DRB CASE ACTION LOG (Preliminary/Final)

DRB Application No.: 10DRB-70025 Project # 1008050

Project Name: Shambauh's Subdivision of Tract 66

PLAT
OF
LOTS 6-A & 6-B
SHAMBAUGH'S SUBDIVISION
OF TRACT 66 - AIRPORT UNIT

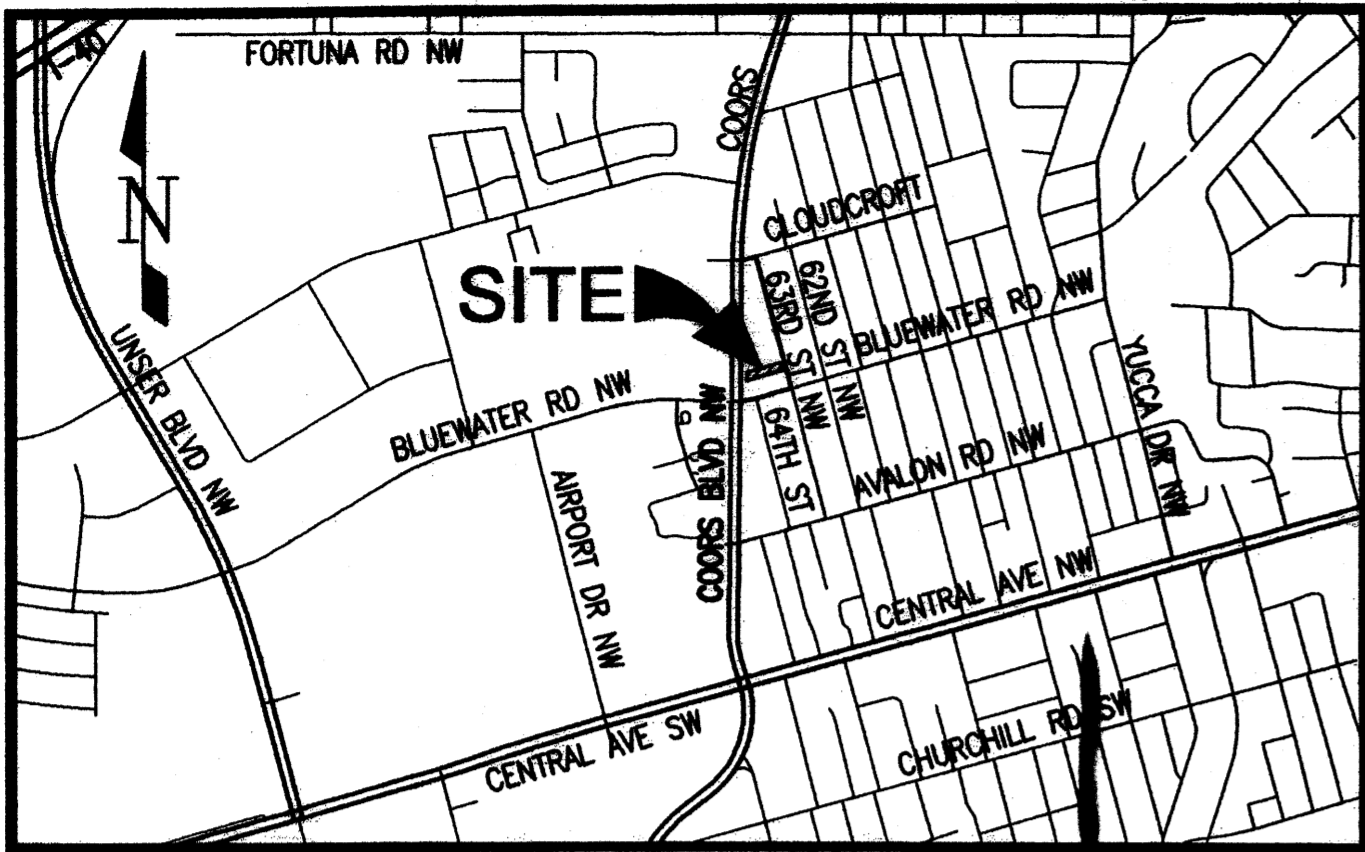
- TRANSPORTATION:** - comply w/ comments
- ABCWUA:** _____
- CITY ENGINEER / AMAFCA:** _____
- PARKS / CIP:** _____
- PLANNING (Last to sign):** - label Easement for "Private" Utility
- call out Maintenance & Restrictions

CLYDE J KING agent(s) for GARY JOHNSON request(s) the above action(s) for all or a portion of Lot(s) 6, **SHAMBAUH'S SUBDIVISION OF TRACT 66**, zoned R-1, located on COORS NW BETWEEN BLUEWATER RD NW AND LOS VOLCANES NW containing approximately 0.4299 acre(s). (J-10) **THE PRELIMINARY/FINAL PLAT WAS APPROVED WITH FINAL SIGN OFF DELEGATED TO COMPLY WITH COMMENTS AND TO PLANNING TO LABEL EASEMENT FOR "PRIVATE" UTILITY AND TO CALL OUT MAINTENANCE AND BENEFICIARIES.**

The site is within the Coors Corridor Sector Development Plan, and would be subject to the design regulations of the plan. A minimum 15 foot easement would be needed across the proposed lot that fronts on 63rd Street for access to the 'rear' lot.
